Elite Nugen
The White Lodge
Rectory Lane
Angmering
BN16 4JU

Please ask for: Ms Iqraa Malik
Email: iqraa.malik@terraquest.co.uk
Telephone: 0121 234 1390
Our Ref: A/230/21/L
Your Ref:
Date: 3rd November 2021

Listed Building Consent for Alterations, Extension or Demolition of a Listed Building

Development: Erection of two storey side extension. (This application may affect the character and appearance of the Angmering Conservation Area)
Location: The White Lodge Rectory Lane Angmering BN16 4JU

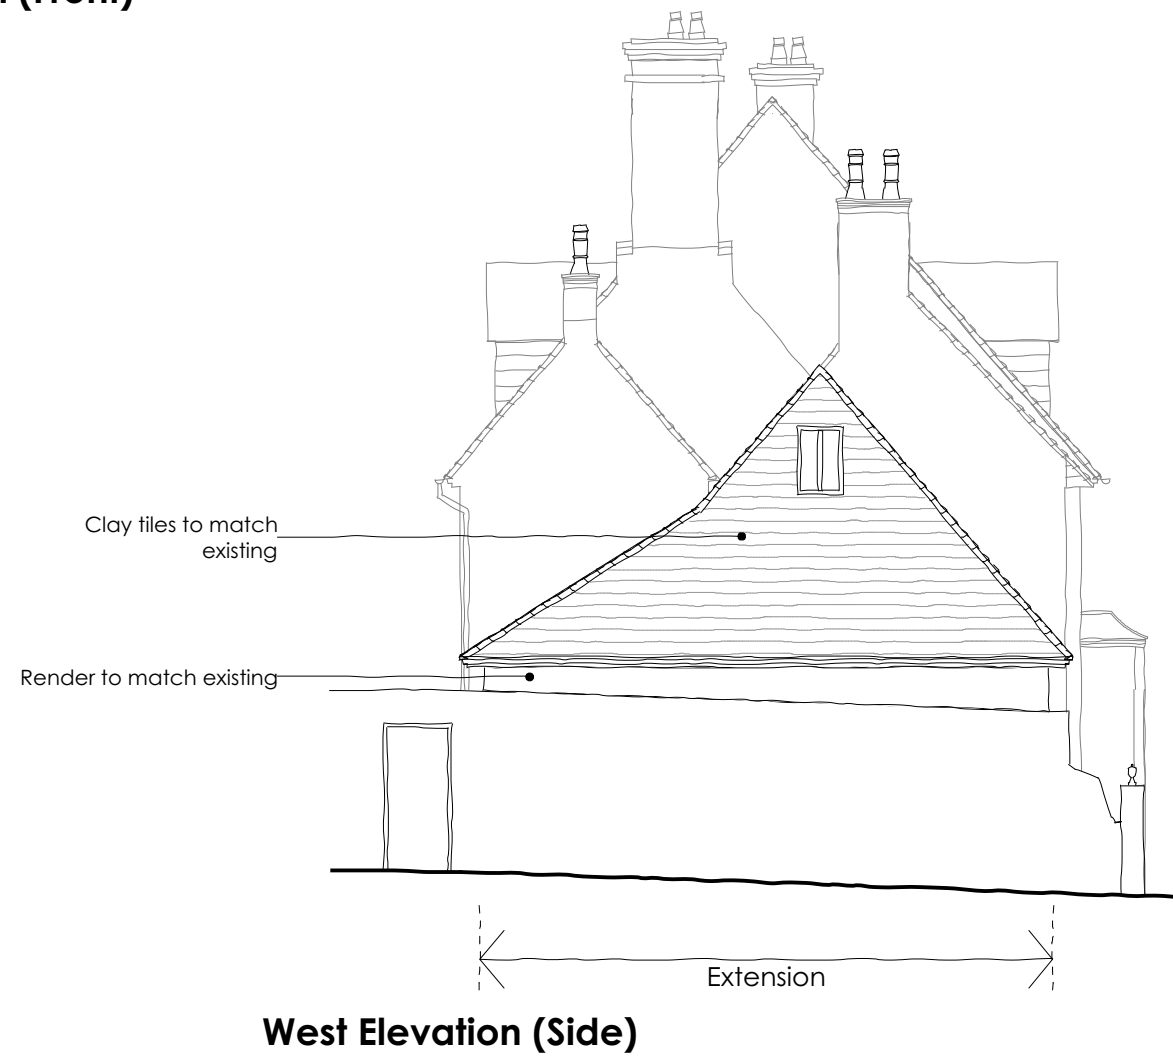
The windows are inconsistent between the proposed first floor plan and proposed rear elevation. Please review and amend.
